From
The Member-Secretary,
Madras Metropolitan
Development Authority,
No.8, Gandhi-Irwin Road,
Madras-600 008.

Letter No. B3/14694/96.

Sub: MMDA - Construction of BF+GF+3 of office
building @ door no 145, T.T.K. Road, Alwarpet in

X.S. no 3706/3, ~~Alwarpet Ms.~~ Block no 73 of ~~in~~ ^{ms} - Remittance of charges
Requested - Reg.

SFT
PLOT EXTENT	5134
BASEMENT FLOOR	1694
GROUND FLOOR	1694
FIRST FLOOR	1824
SECOND FLOOR	1824
THIRD FLOOR	1824
TOTAL	8860

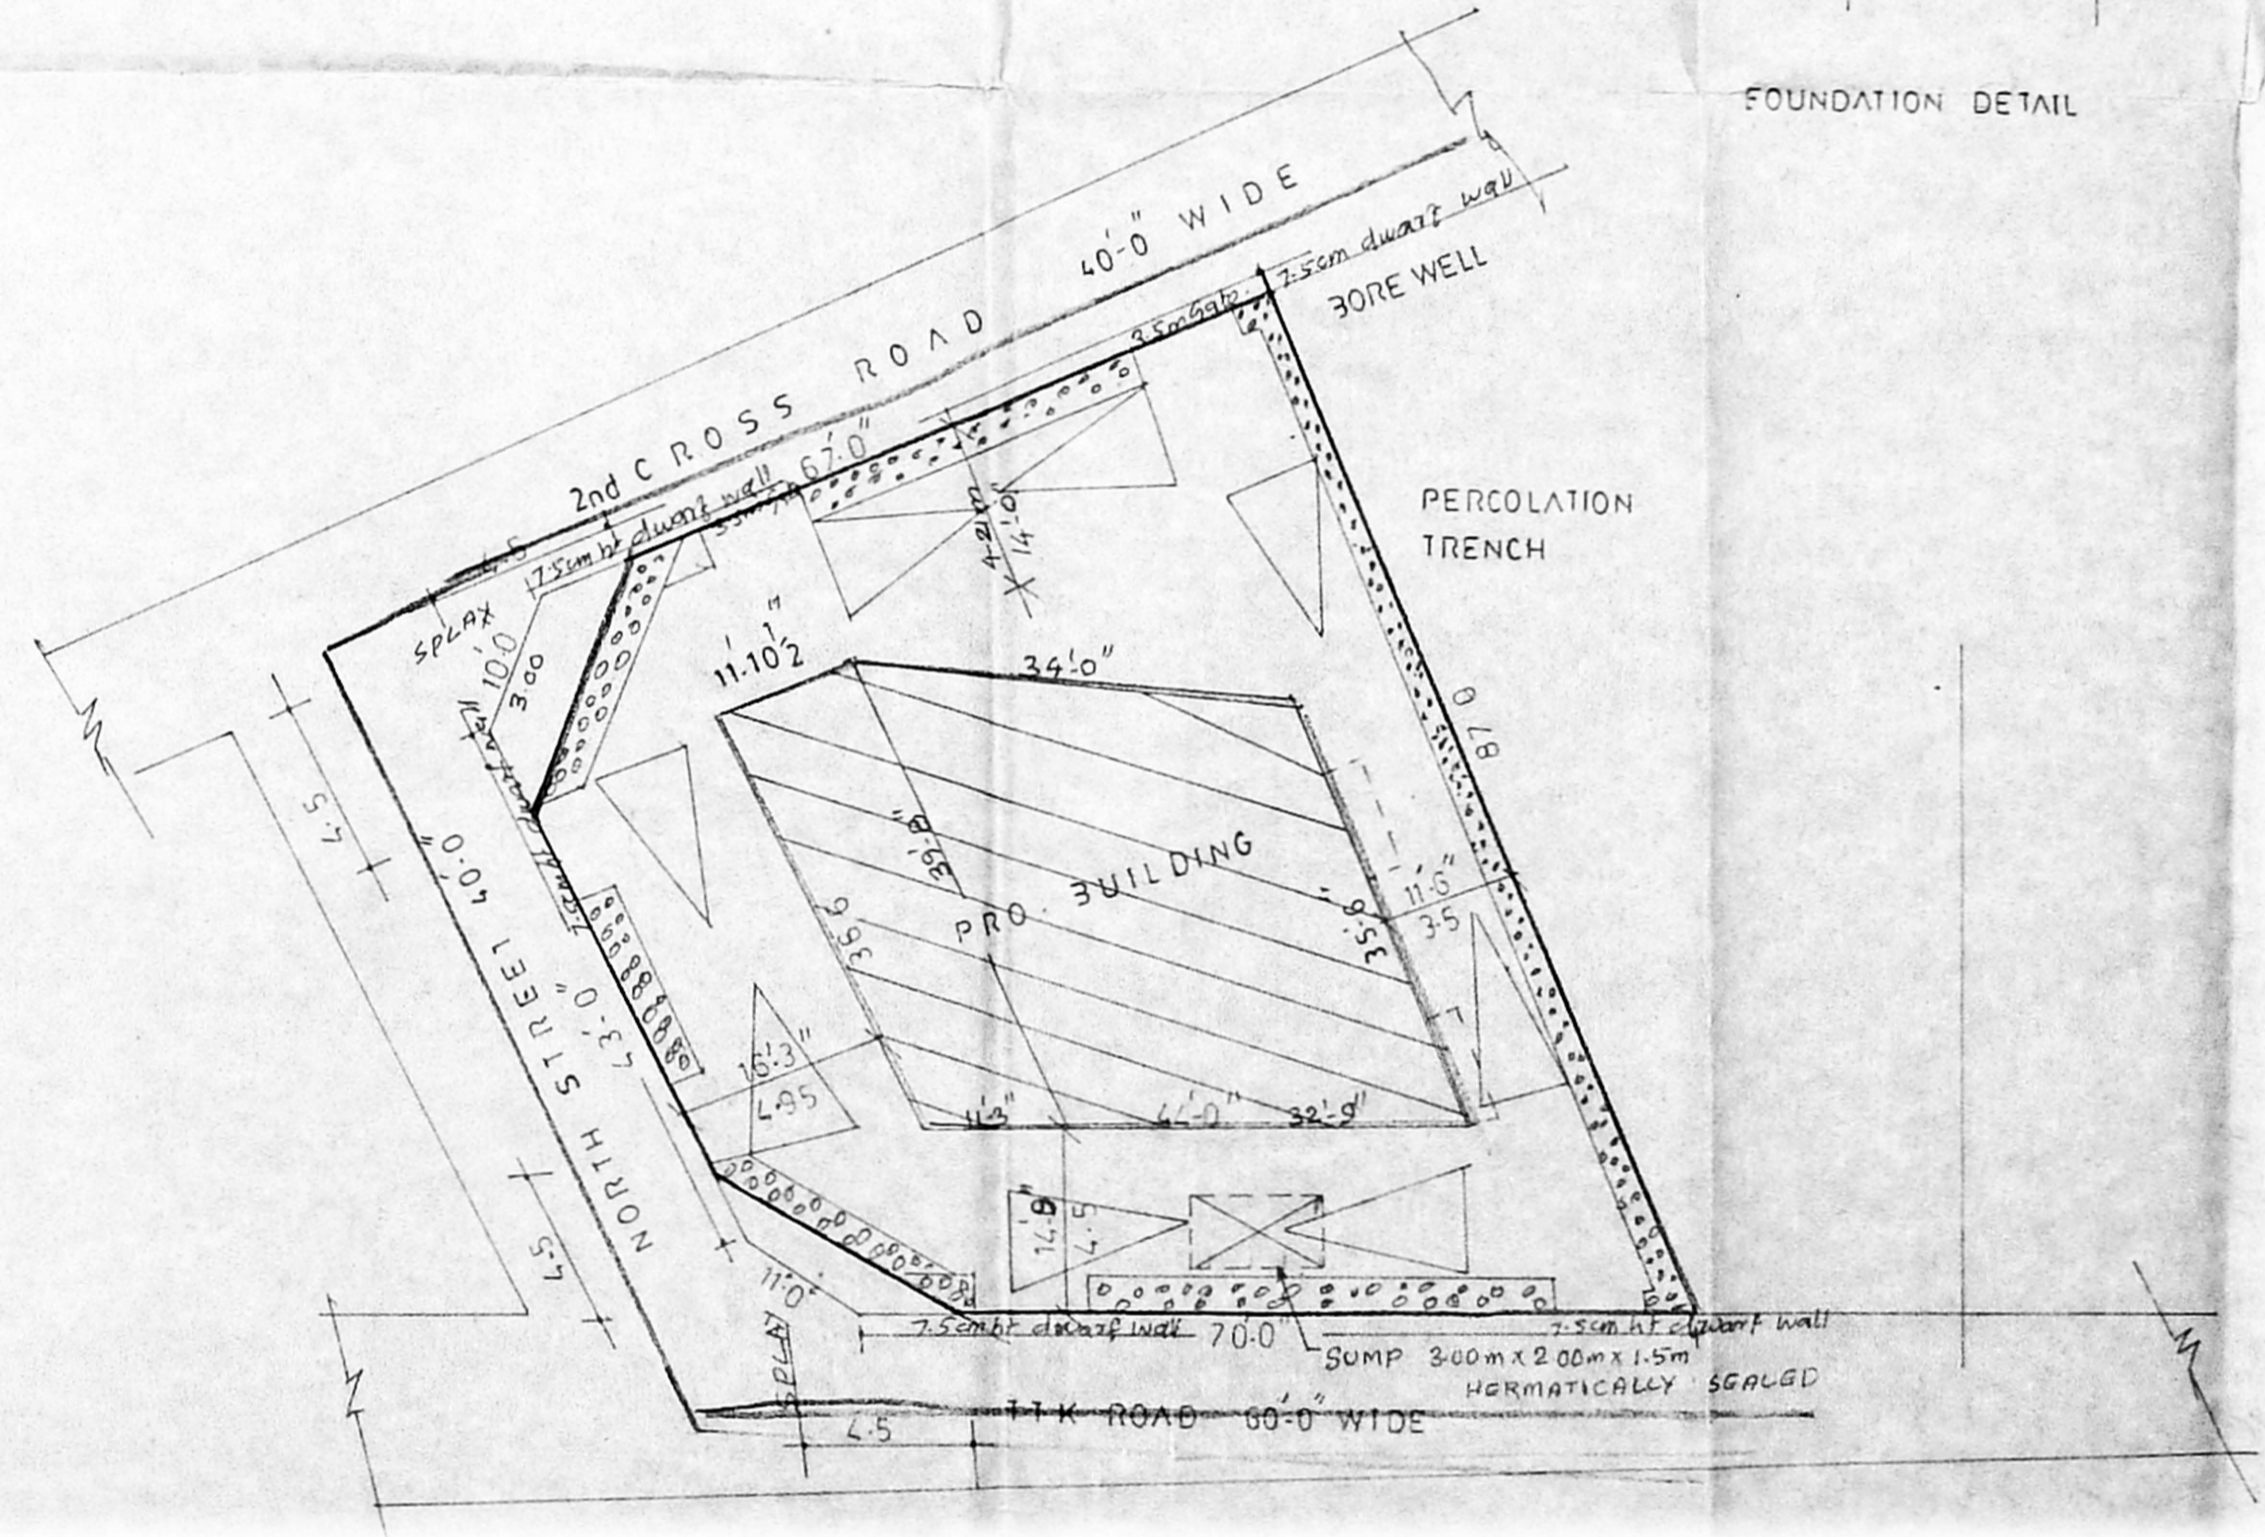
(c) You are requested to furnish the ~~following~~ ^{4 copies of} R.P showing

- i) ~~Setback on west not shown~~ [But more than the Regd 3-16m]
- ii) ~~Site plan to be drawn with specific indication of Splay~~
* left now [i.e. site Boundary to be marked excluding the space left for Splay.]
